Meadowbrook Crossing Filing 2: Review 2 Response to Comments

PCD Engineering Division:

AS REPLATTED

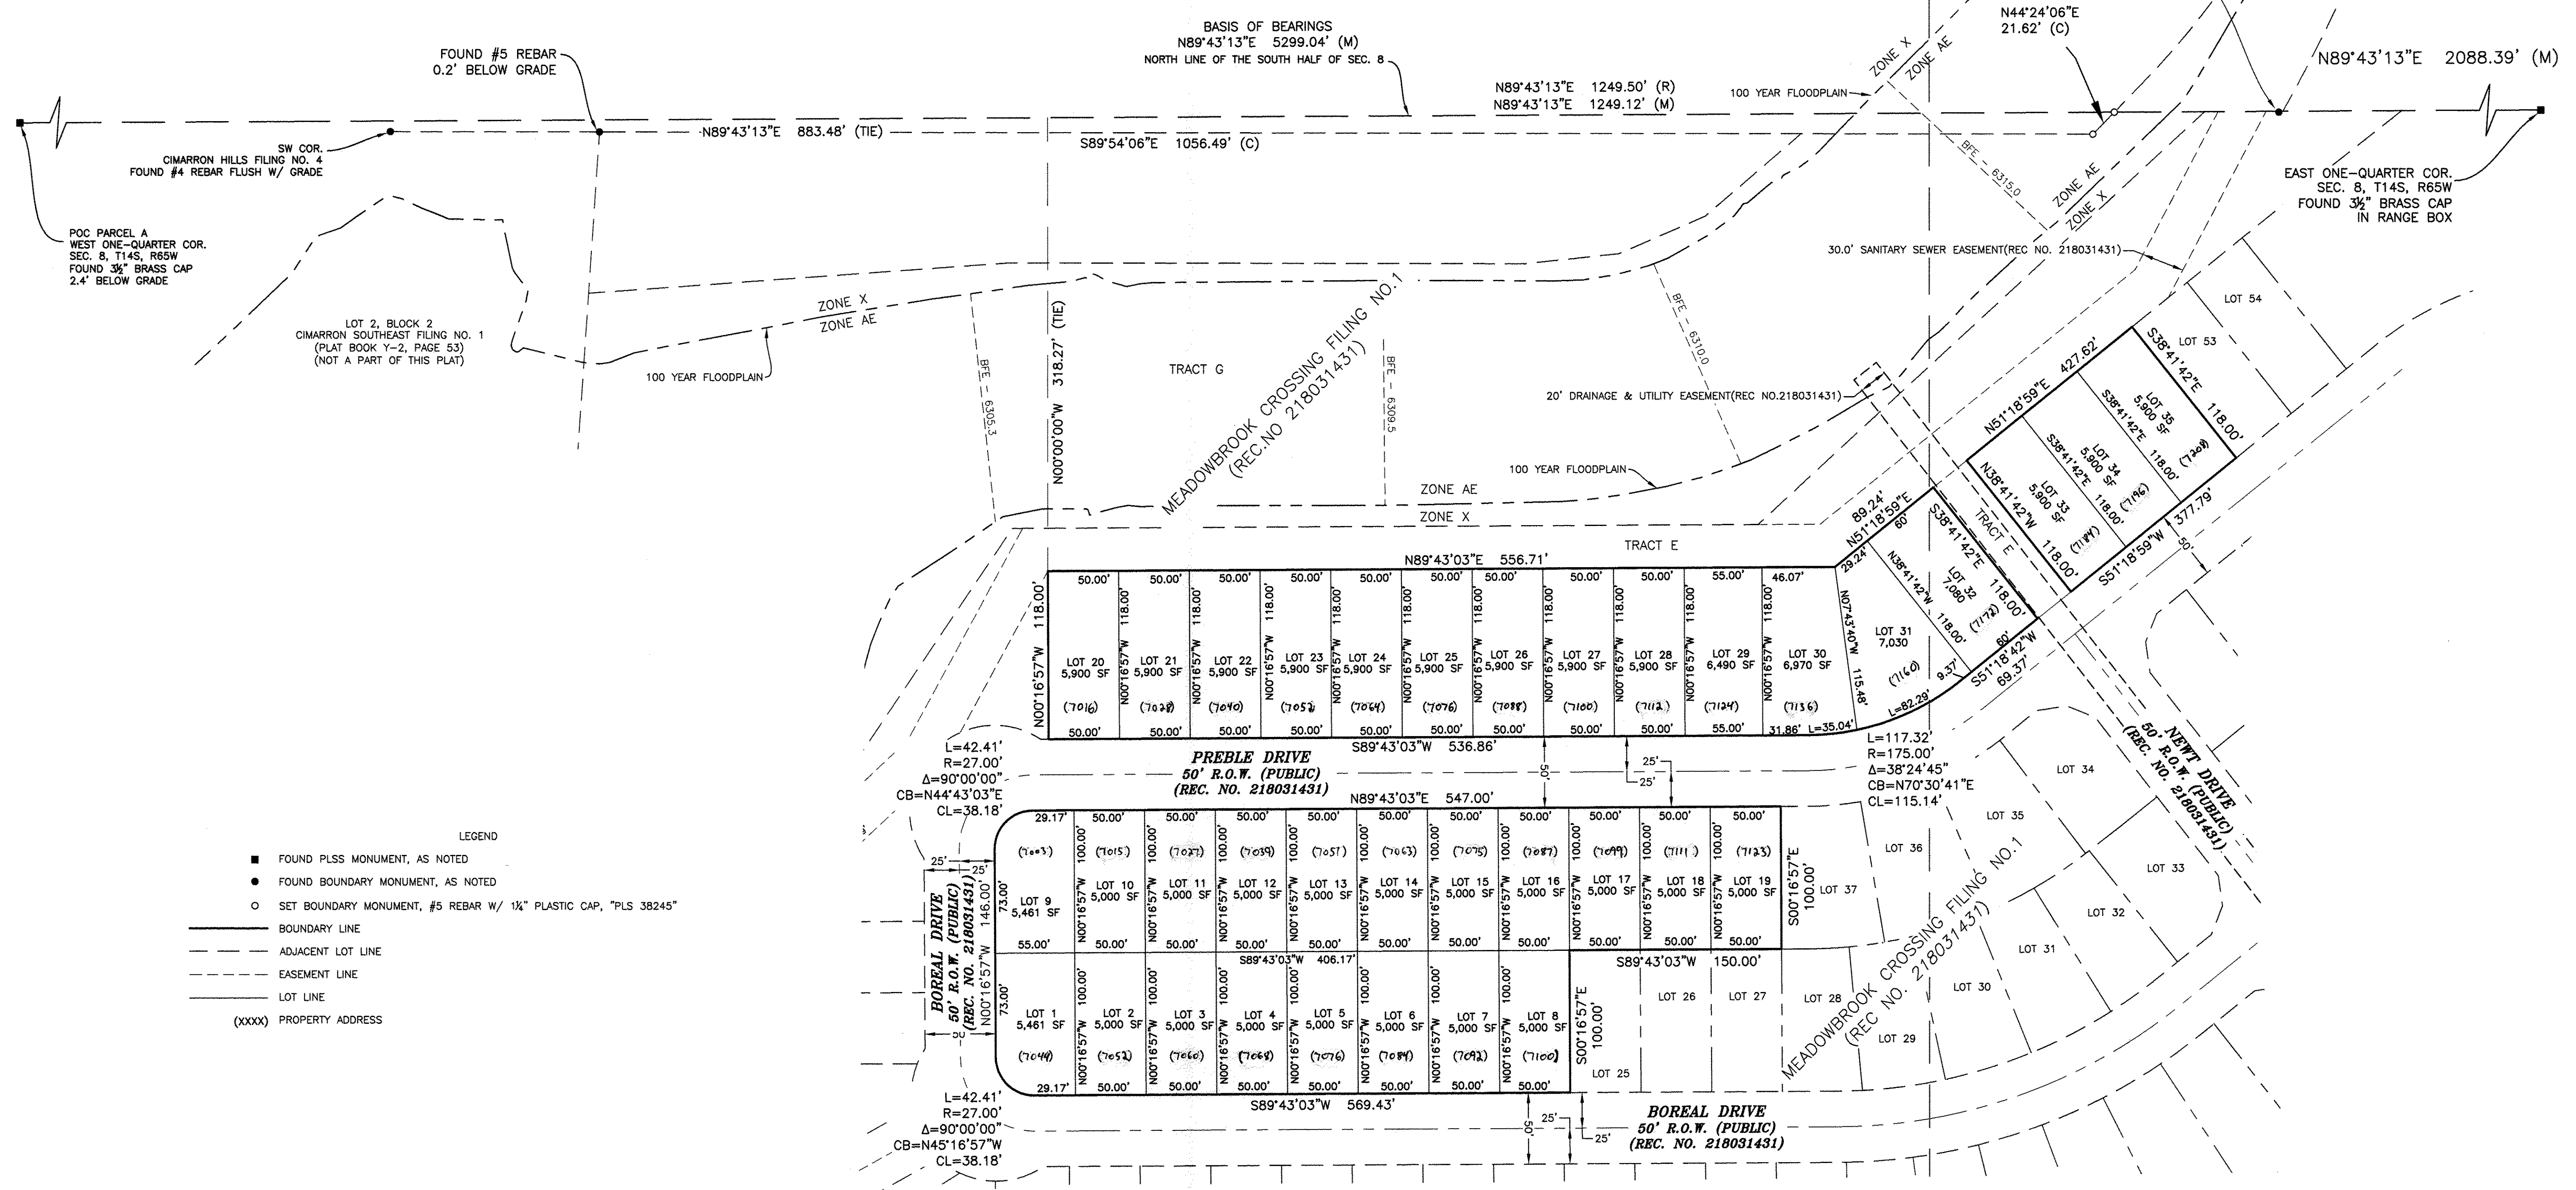
- The FEMA adjusted floodplain boundary must be shown in the "As-Replatted" to reflect the approved LOMR. Per Land Development Code (LDC) Chapter 8 Section 8.4.2.B.1.e, FEMA-approved base flood elevation data shall be shown on the plat. Review 2 comment: Unresolved comment. Per the referenced LDC section above, the plat shall identify the FEMA approved base flood elevation on the plat.

RESPONSE: The Base Flood Elevation lines have been added to the drawing.
